**Case Officer:** Matthew Chadwick      **Recommendation:** Approve

**Proposal:** Alterations to facilitate the conversion of the existing building into a residential dwelling. Works to include repair of the existing walls (to be internally insulated), creation of minor openings within the building, and to insert a new window. Existing openings are to be enclosed with glazing.

TITLE	Proposed North and South Elevations
-------	-------------------------------------

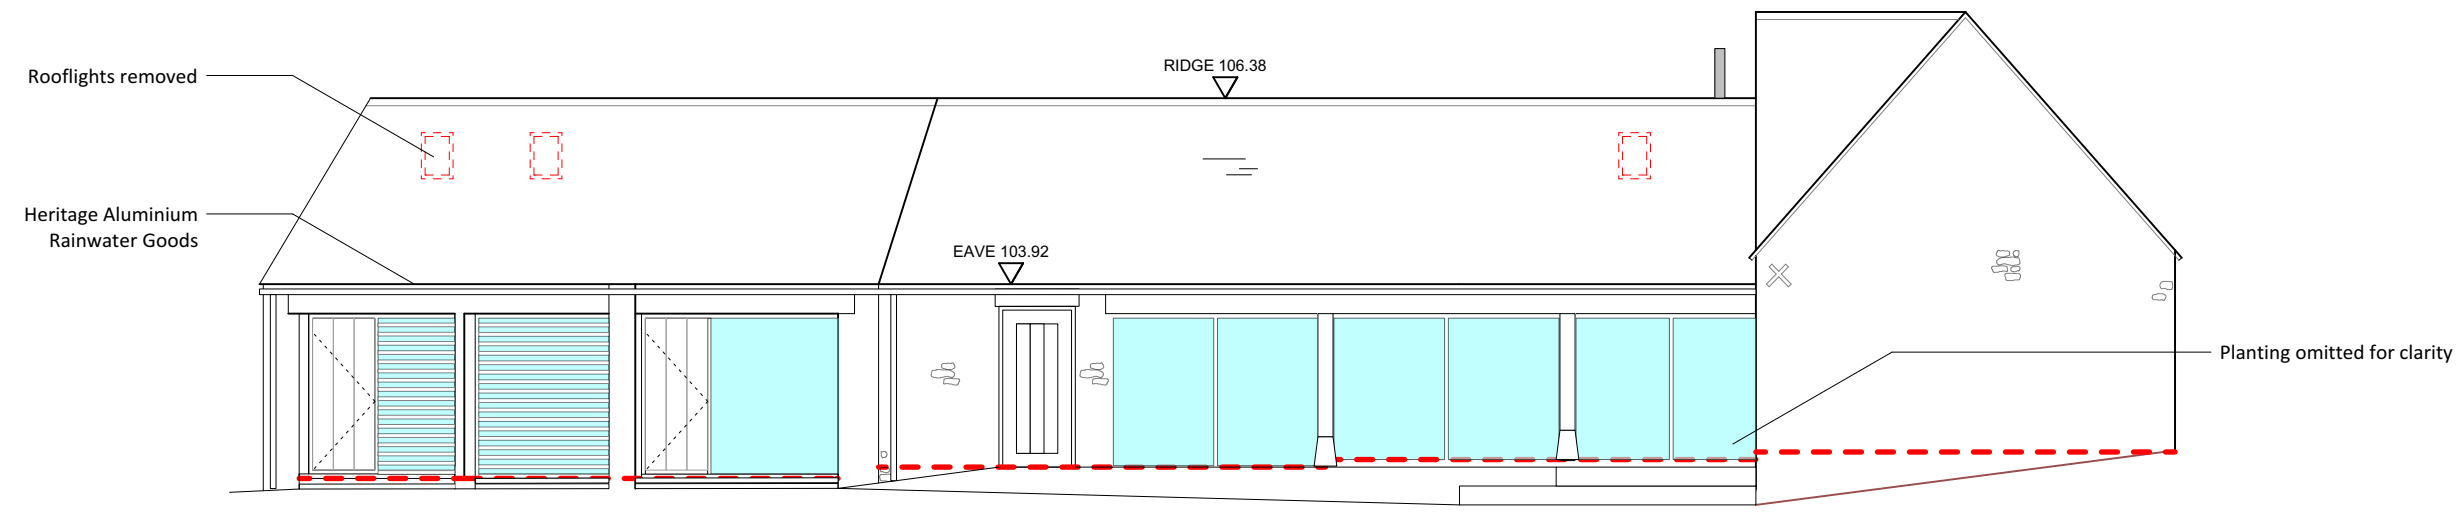
- 6.3. CDC CONSERVATION: Comments that given the expense of glazing to Bedroom 1 it seems unnecessary and overly large. Given the expense of glazing to the kitchen and sitting area, the rooflights here also appear large but more acceptable due to the need for light in the kitchen. The rooflight to Bedroom 3 is overly large within such a small section of roof, and as there is a further natural light source in the proposed full height glazed opening is also to be added in the west elevation.
- 6.4. Suggests conditions relating to masonry samples, black metal rainwater goods, services, joinery details, roofing samples, landscaping details and structural details.

- 8.5. The Conservation Officer initially recommended refusal on the application but the main element of concern, the replacement of the protruding element to the north of the building, was subsequently removed from the proposals.

- 8.6. The development seeks to create new openings in the northern and western elevations of the building and introduce rooflights into the southern roofslope. These alterations would result in the loss of existing fabric by the removal of a section of the exterior walls and roof of the building. Two openings are also proposed in the internal walls to create doorways for the circulation space of the building. This loss of historic fabric would result in less than substantial harm being caused to the significance of the curtilage listed building.

- 8.9. The Conservation Officer has raised concerns regarding the proposed rooflight over bedroom 3. The building has historically had rooflights in both its northern and southern roof slopes. The bedroom with the rooflight would only be otherwise served by a single opening on the west elevation.

- 8.10. The provision of rooflights would cause some harm to the significance of the listed building. However, the number of rooflights is limited to those which are considered essential to provide natural light to the new living spaces. This harm will be weighed at para 8.12 below.
